Our Ref: EN010117

### **Proposed Application by Rampion Extension Development Limited for an Order Granting Development Consent for the scheme Rampion 2 Offshore Wind Farm – EN010117**

#### **Advice following issue of decision to accept the application for examination**

VER	DATE	REMARKS	DRAW	CHEK	APRD
01	14/09/2023	DRAFT	LB	NC	UP
02	15/09/2023	FINAL	LB	NC	UP

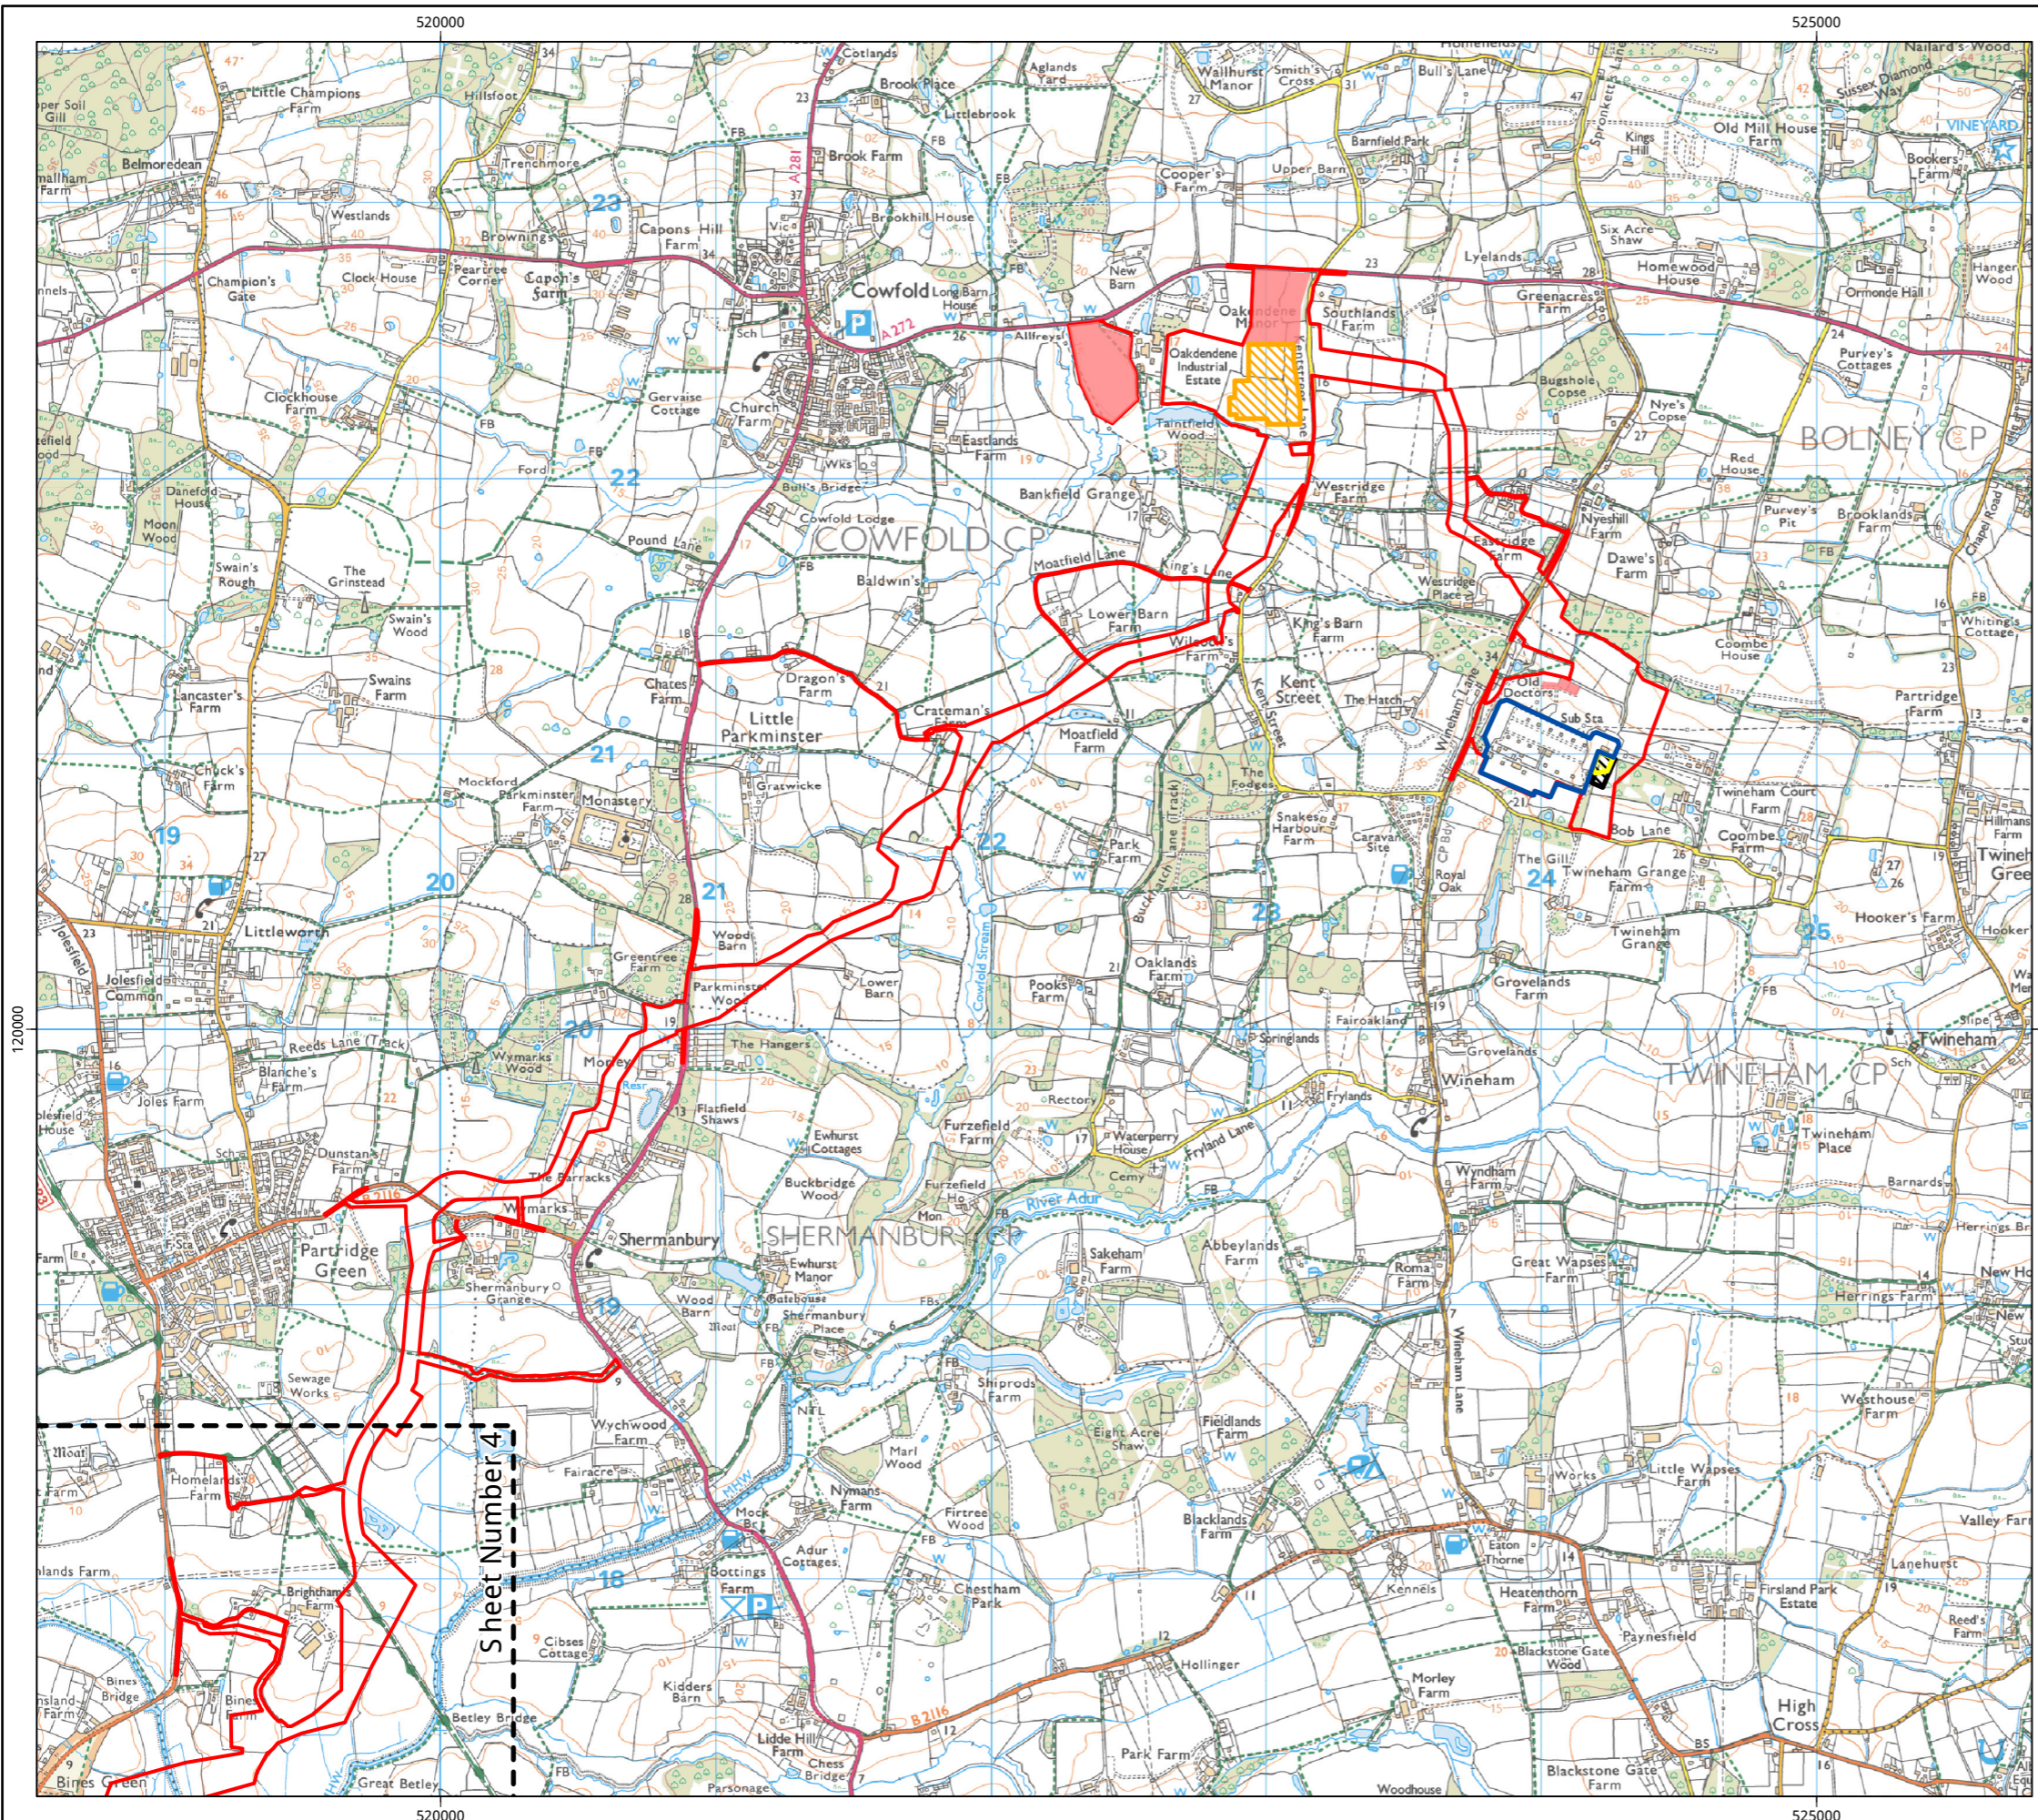
The Inspectorate notes there are no Onshore General Scheme Outline Plans. It is advised that such plans are submitted and that they clearly show arrangements of onshore cable routes.
